Your Ref: OWPC25140
Our Ref: FG/141/19/PL 13-11-2019
Please ask for:
David Spring

Erection of 1 No detached chalet style dwelling with integral garage; demolition of existing conservatory & porches & erection of single storey side extension & part single/part two storey side extension to Elm Lodge (resubmission of FG/220/18/PL).

Elm Lodge Tamarisk Way Ferring

Thank you for your internet representation made on 1st December 2019 which has been recorded as '**an objection**' with the comments as follows:

PROPOSED GROUND AND
FIRST FLOOR PLANS
(PROPOSED NEW DWELLING)

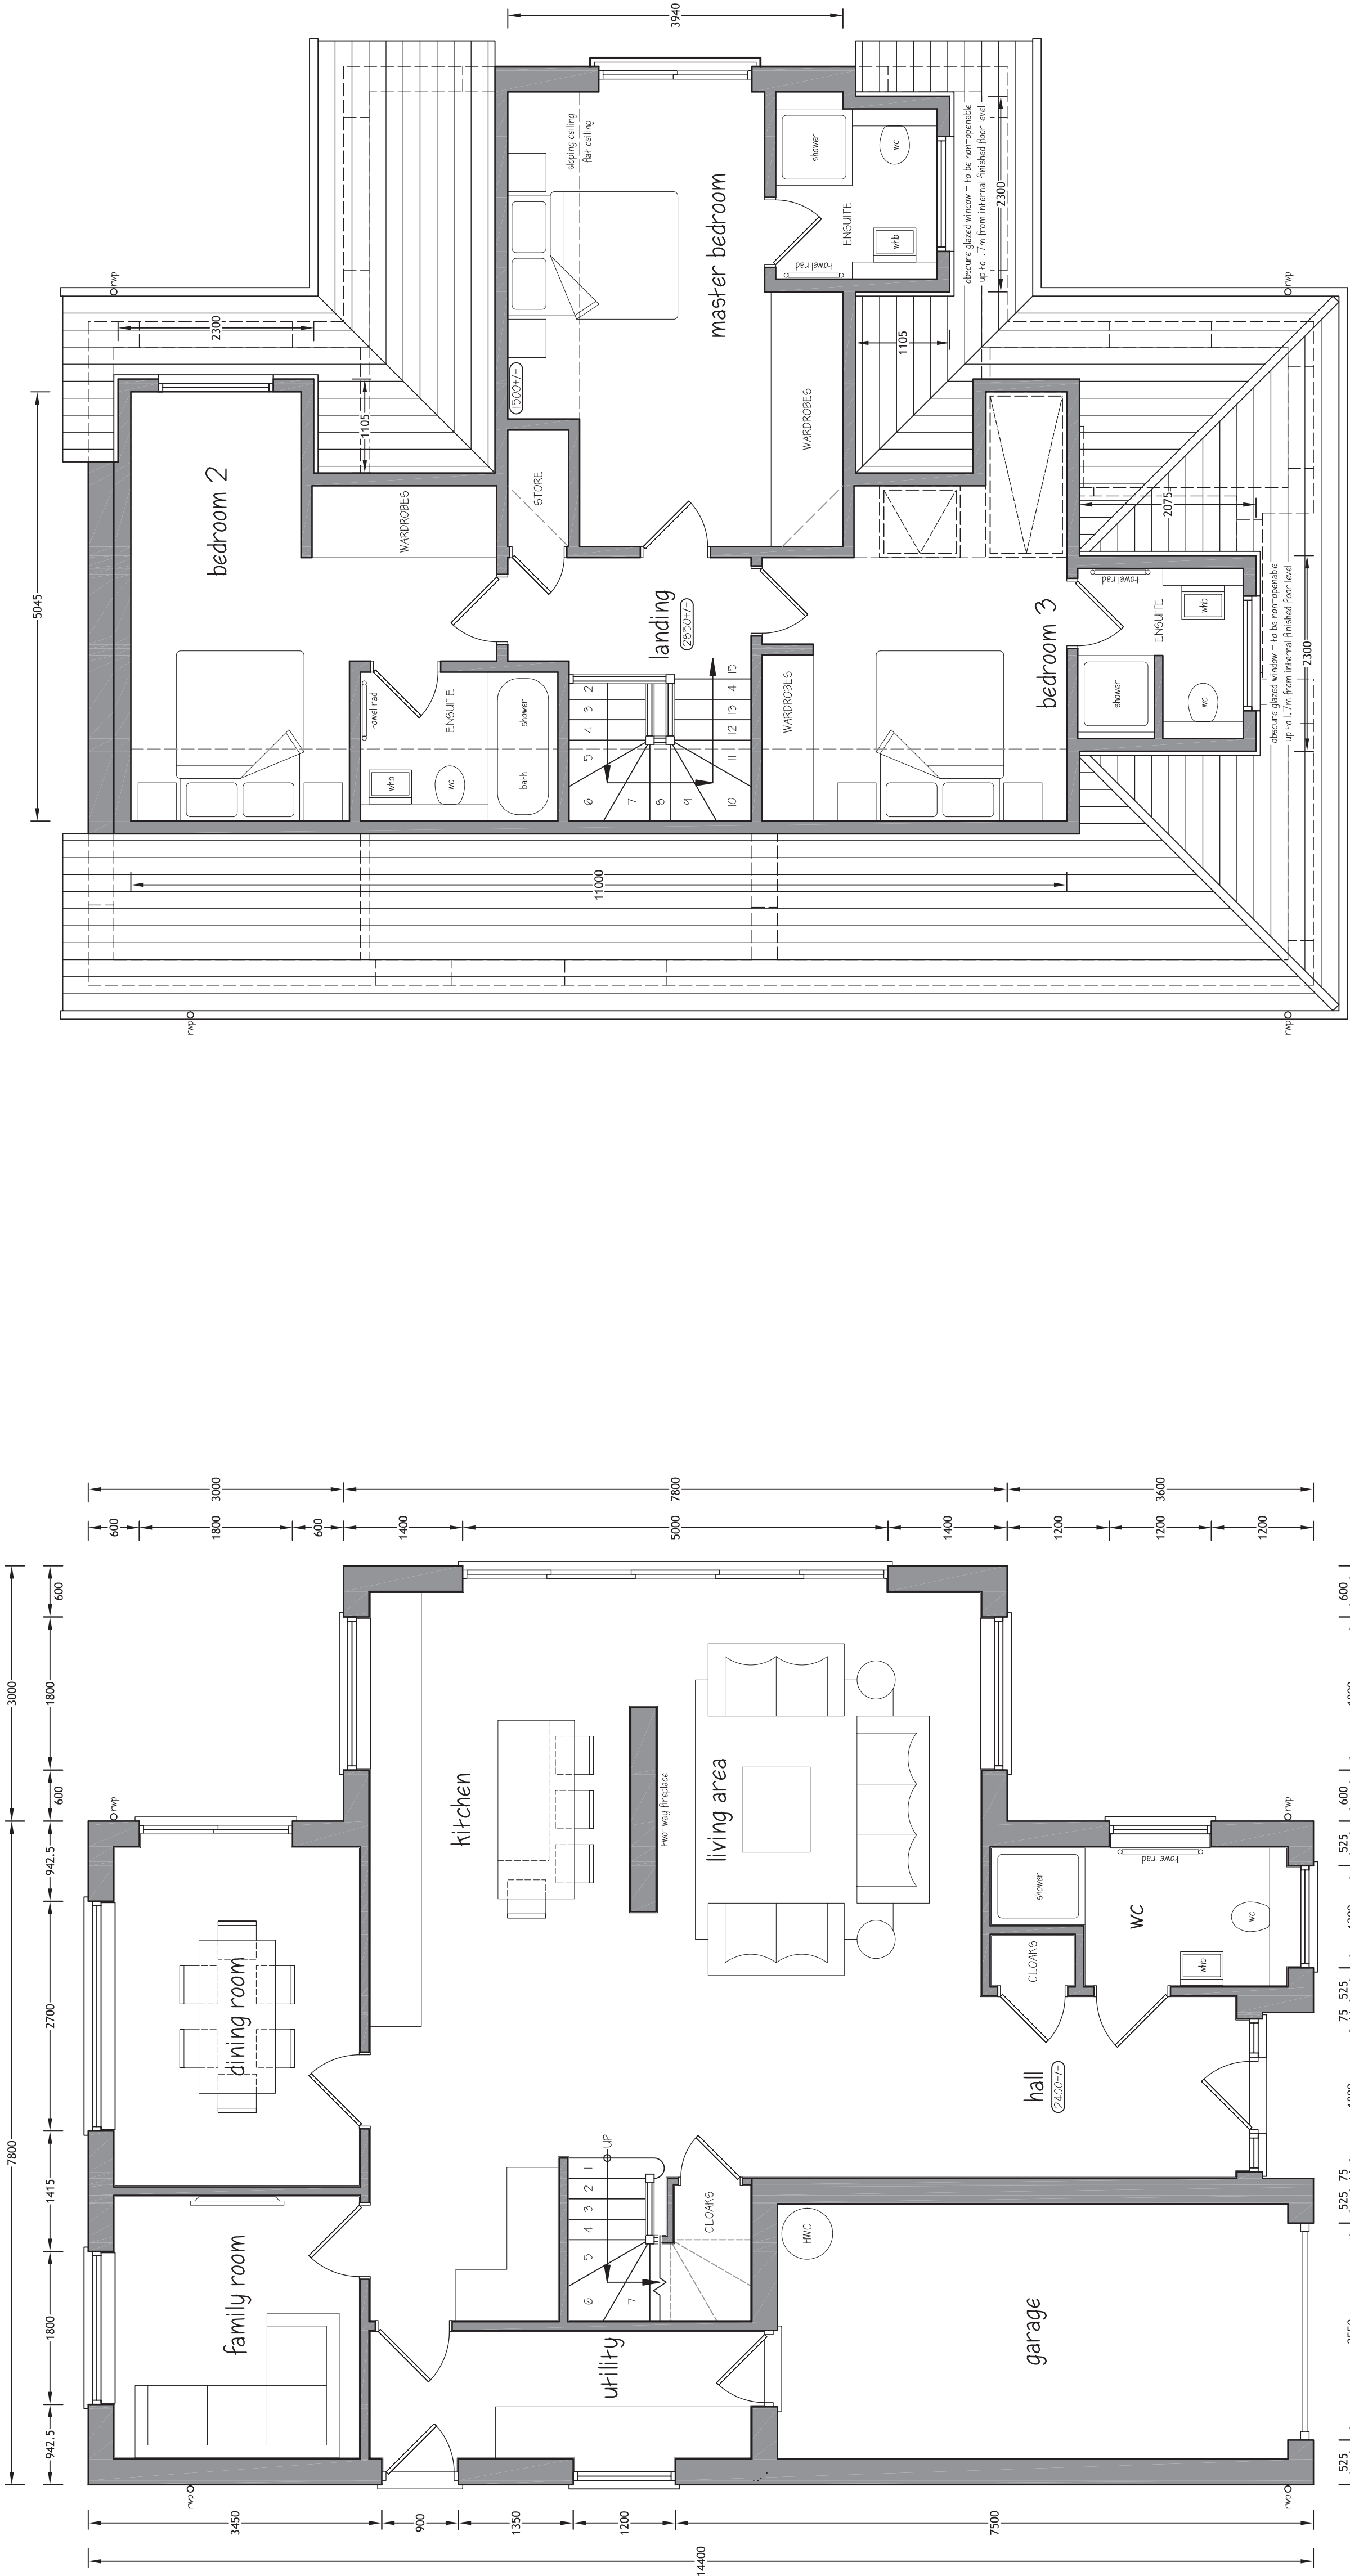
The appellant's revised application (FG/140/19) is hardly different from the application which was refused by the Council and dismissed on the appeal. The layout of the building is almost the same and it is just as close to the host dwelling. Changes in the arrangement of windows do not change the proximity of the buildings and cannot avoid the cramped and overbearing nature of the development.

PROPOSED SITE PLAN

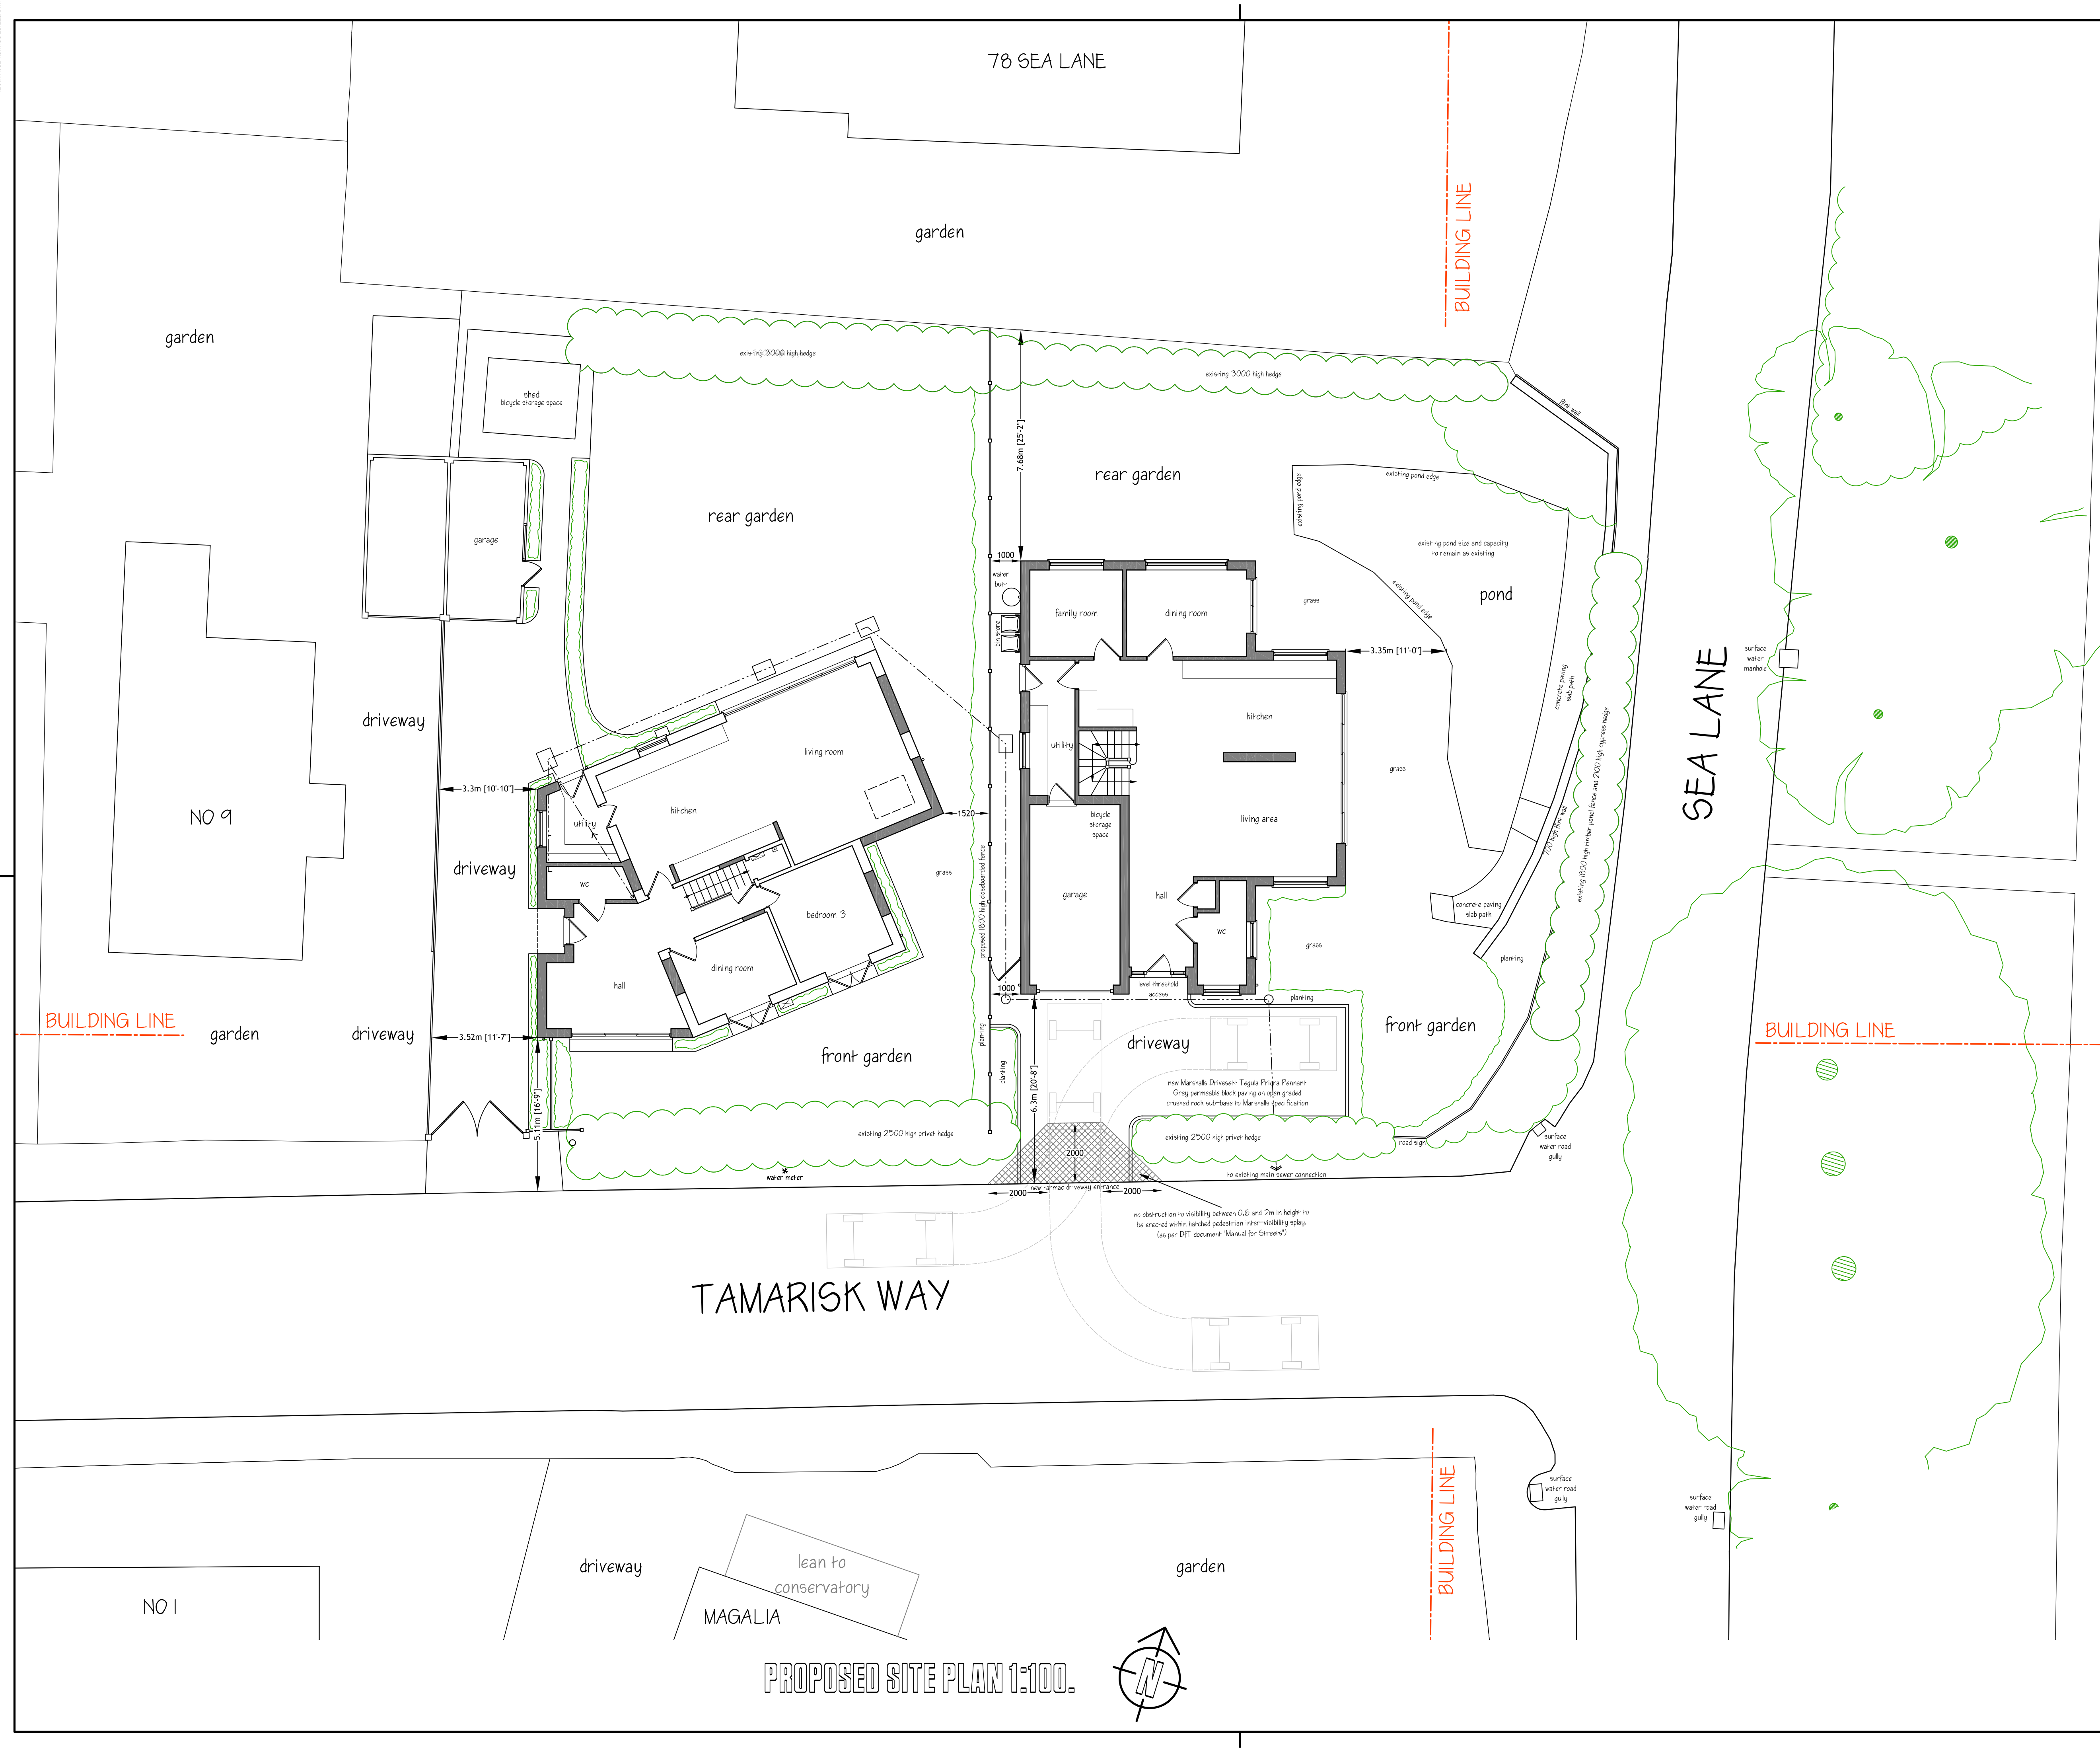
Nor is the impact on Magalia significantly reduced. This application should be refused. Ed Miller (Secretary, Ferring Conservation Group)
